Planning Inspectorate

Our Ref: EN010162

Application by Elements Green Trent Limited for an order granting development consent for the Great North Road Solar and Biodiversity Park

Advice following issue of decision to accept the application for examination

Rev:
Rev01

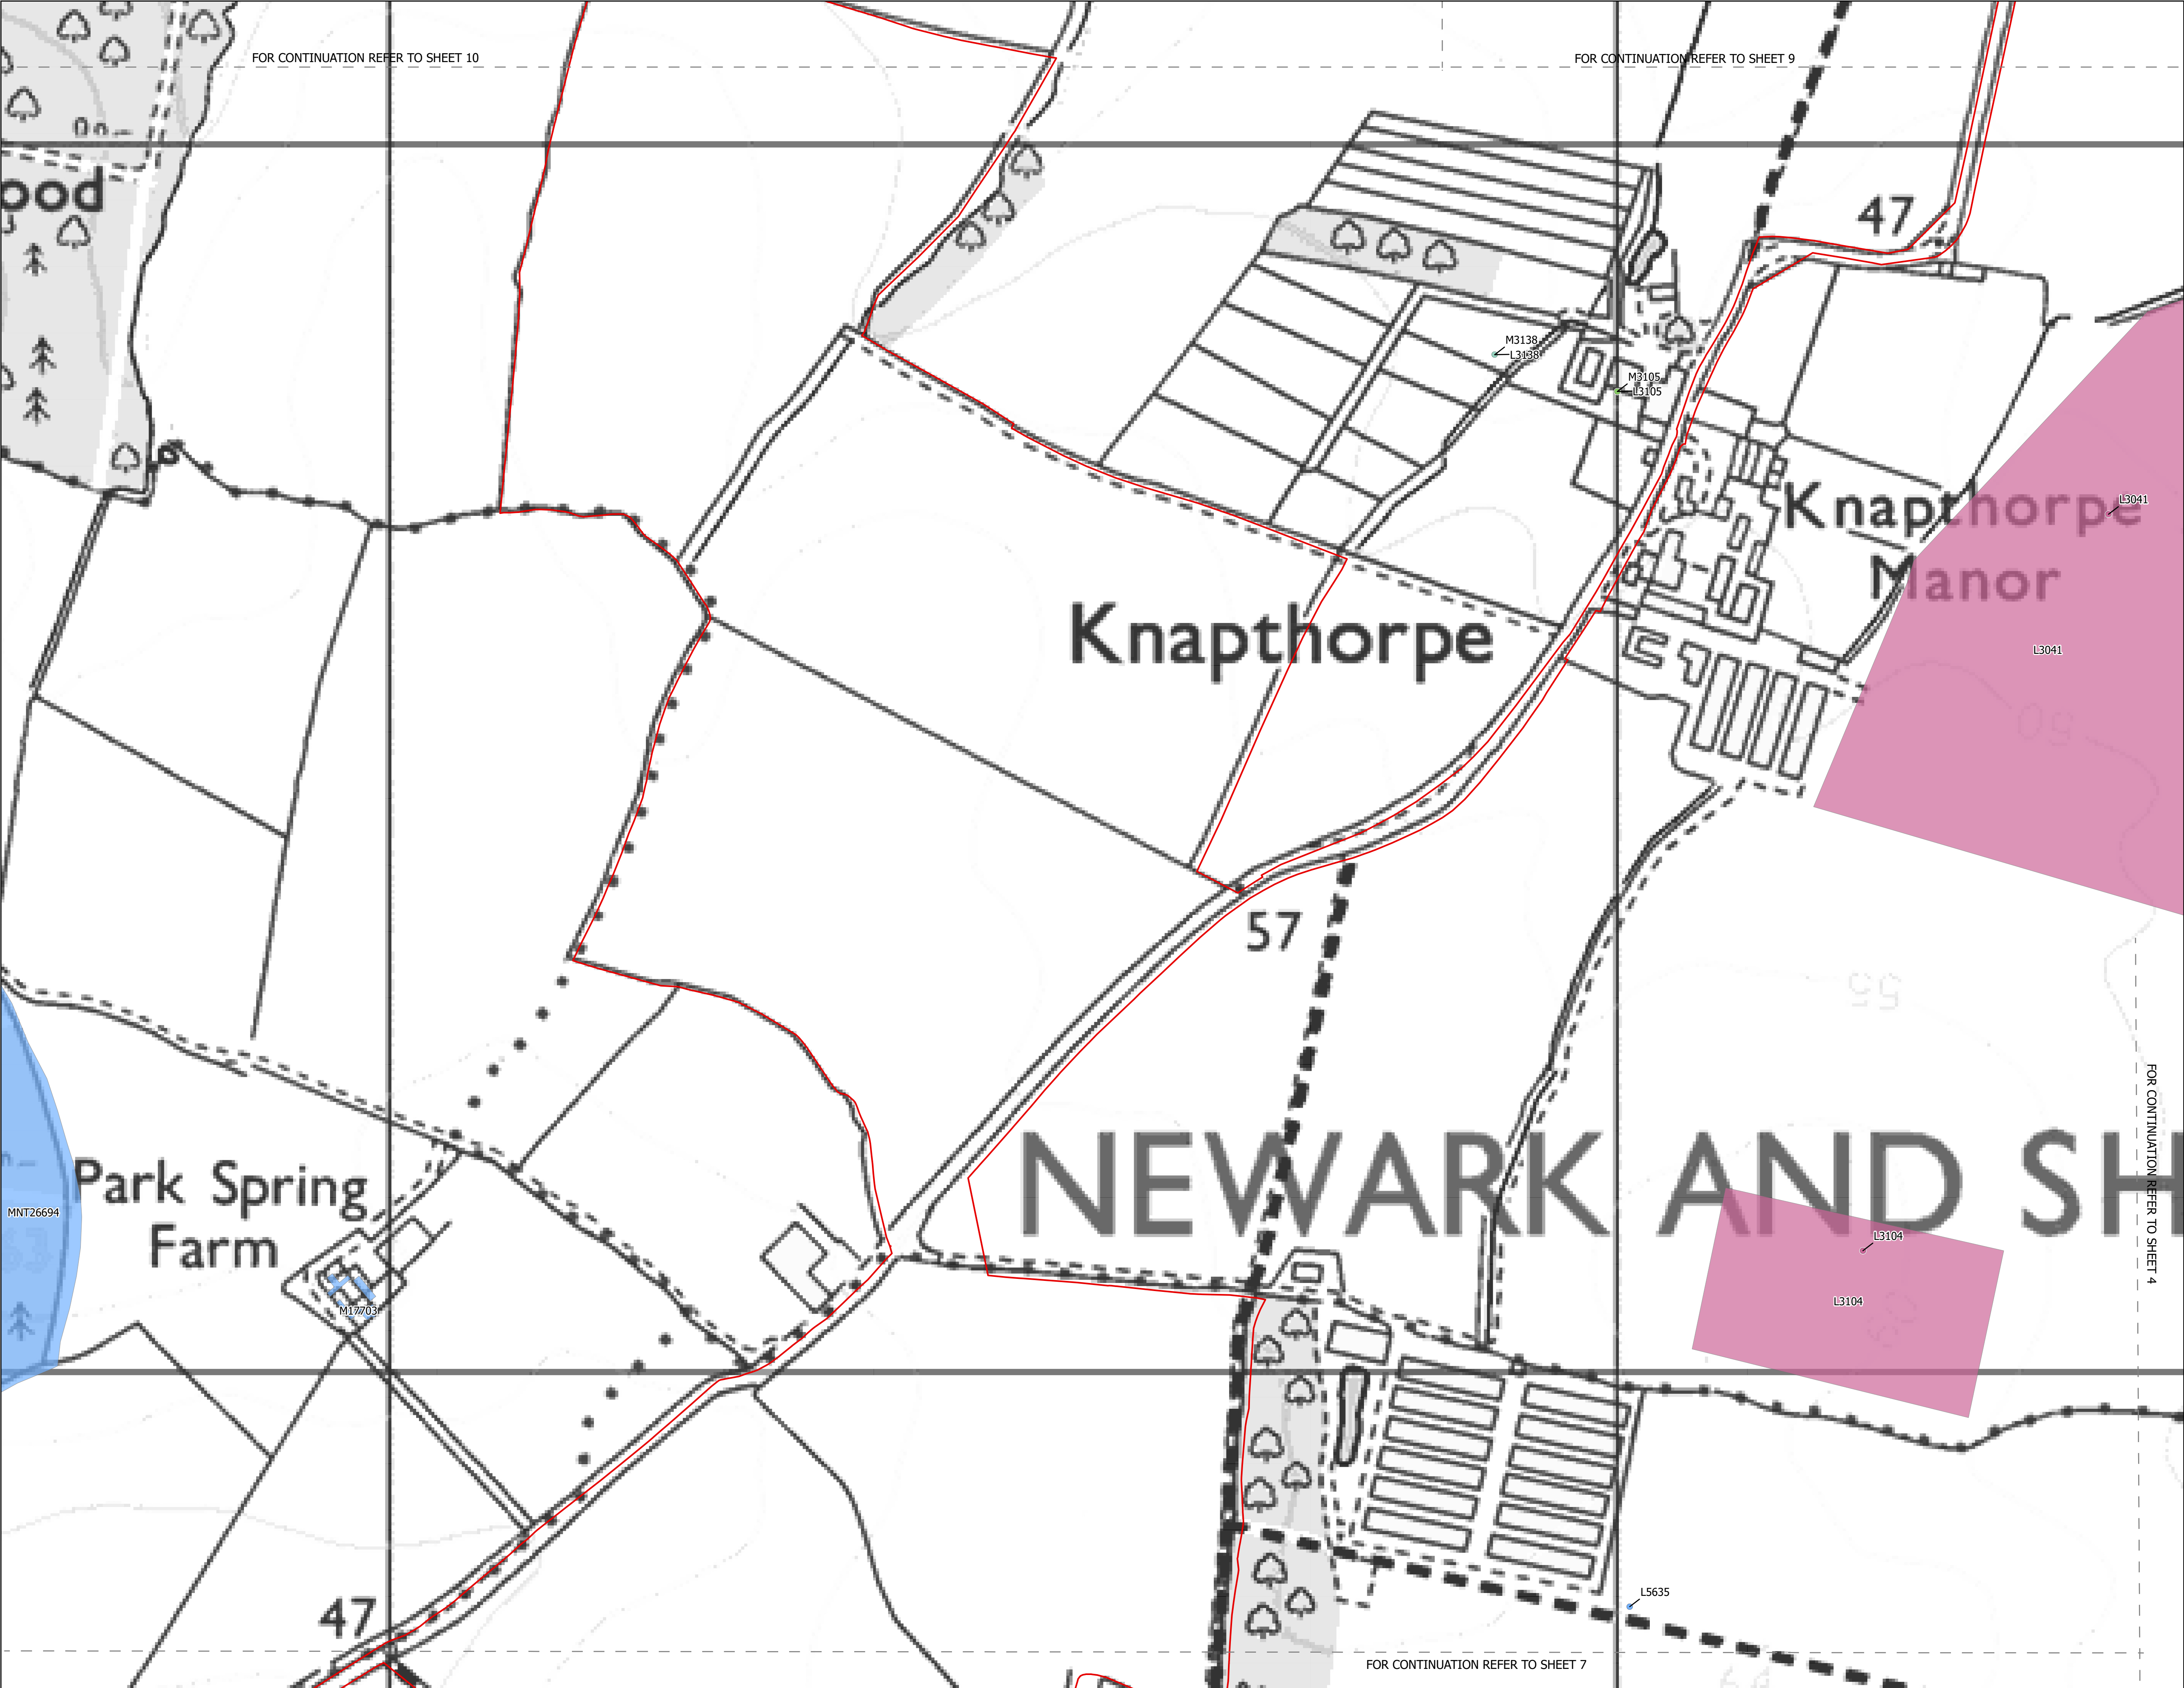
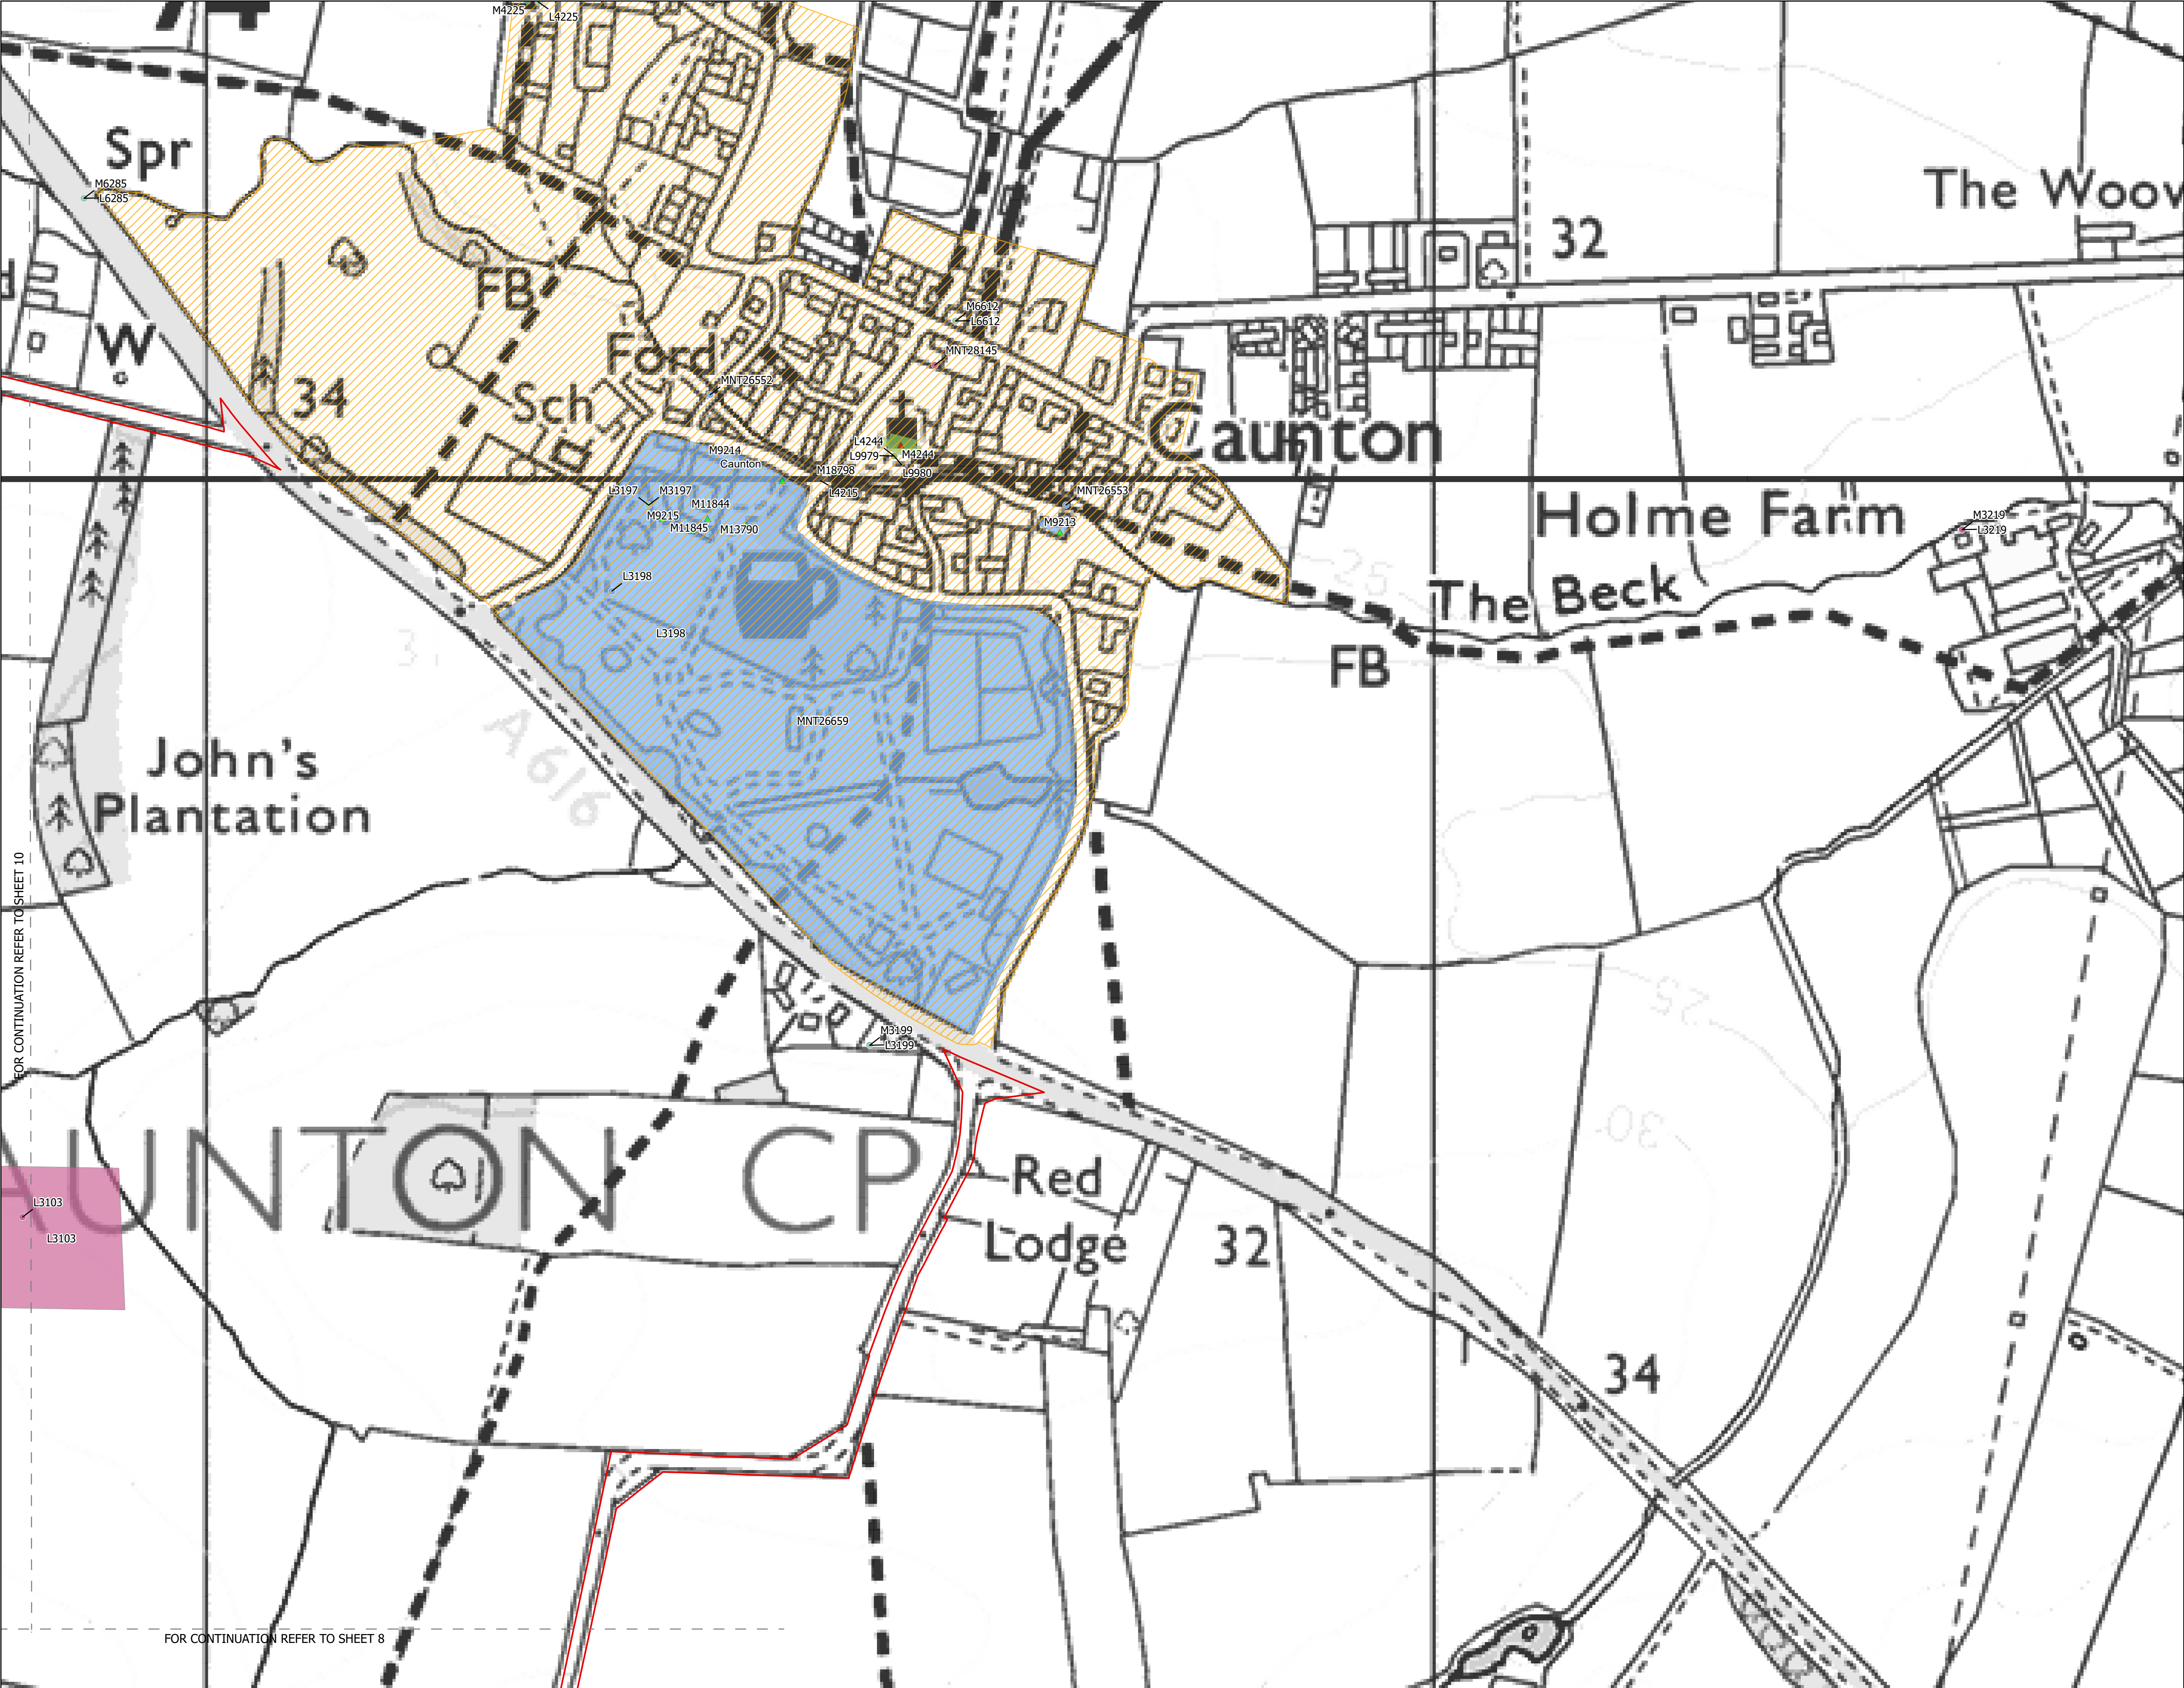
Statutory and non-statutory features of Historic Environment Plan (Doc 2.17)

The applicant is advised to review these figures for clarity, specifically relating to the following points:

- due to the scale of the icons used and similar colouring, it is difficult to differentiate between Historic Environment Record (HER) assets and listed buildings/ grades
- a very similar colouring scheme between HER recorded 'undated' period and scheduled monuments keys has been used
- due to the small scale of the icons, the labelling sometimes obscures the record being shown.
